Letter of Transmittal

CRS# 60465860
Burbank Ranch Housing
Chapter 246-359 WAC Temp. Worker Housing
4 FAS 12 Man Housing Units

Project location: 1121 Burbank Creek Rd
Yakima, WA 98901-8352

Plan Review Comments:

**SITE PLAN**  
SCALE : 1" = 50'

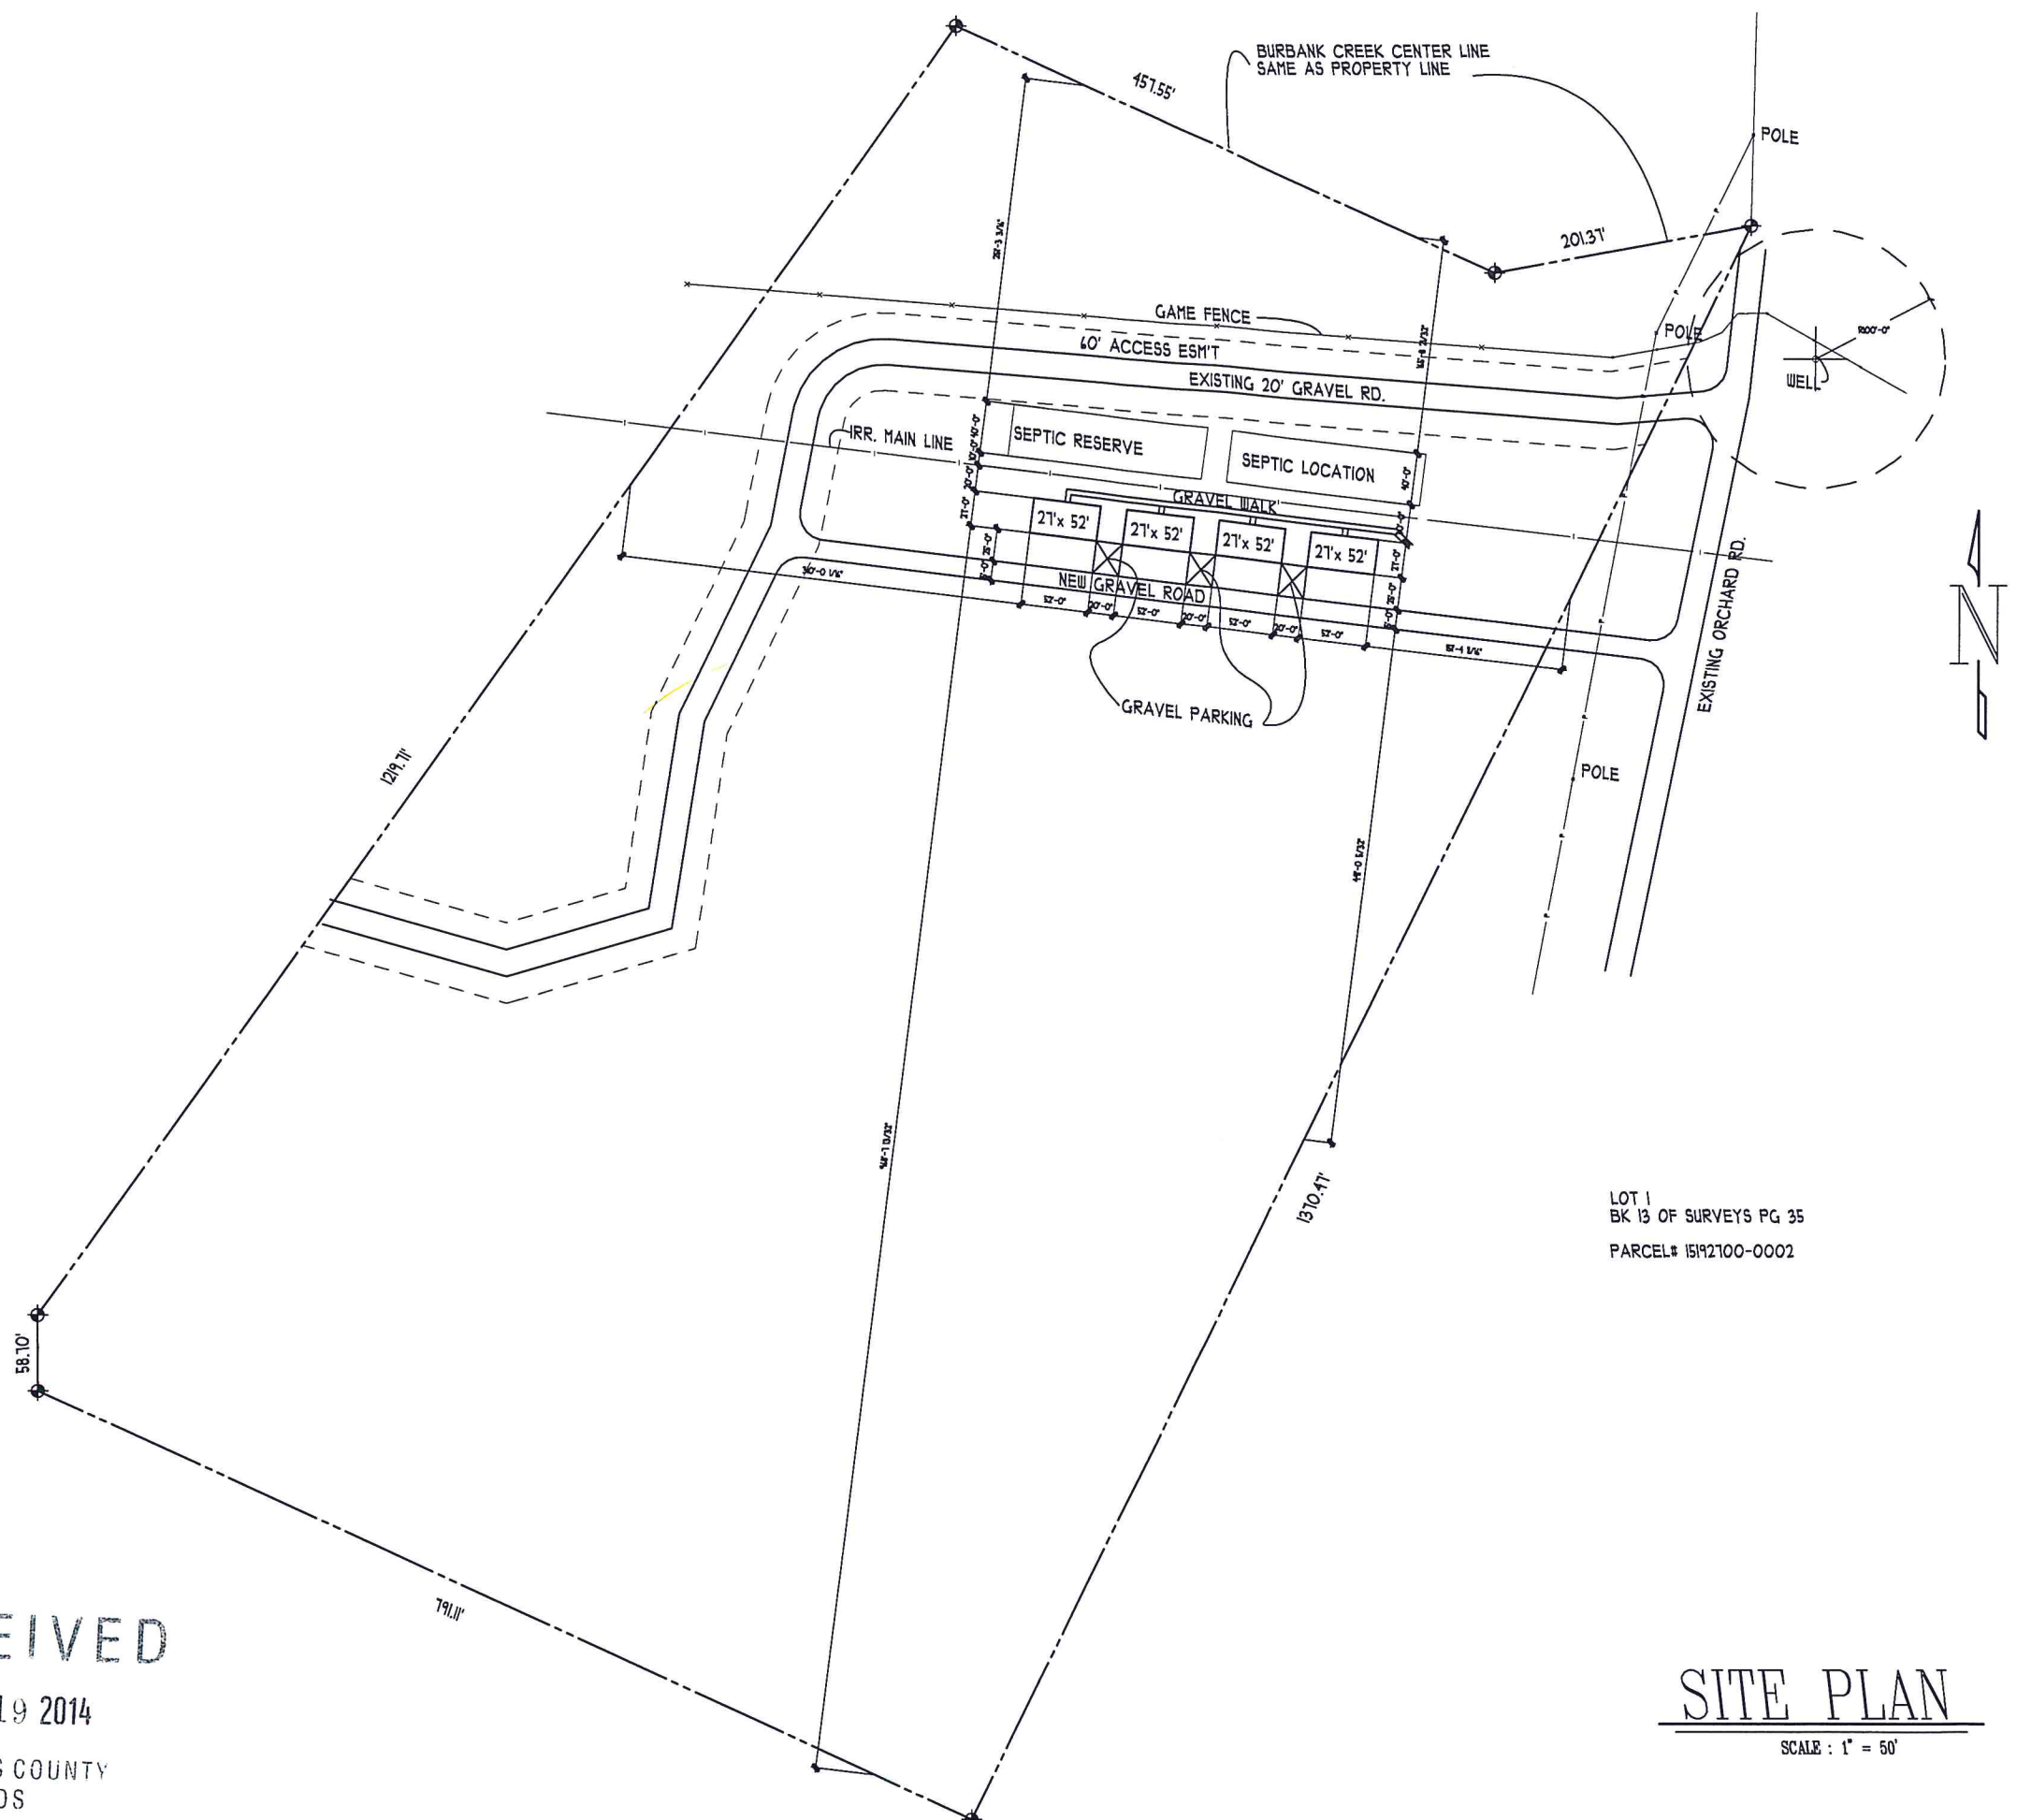
- 2 **Provide a site map and plans for this camp. Include a copy of the Assessor's map number 15-19-27000-0002, and directions to get to the site. sai**
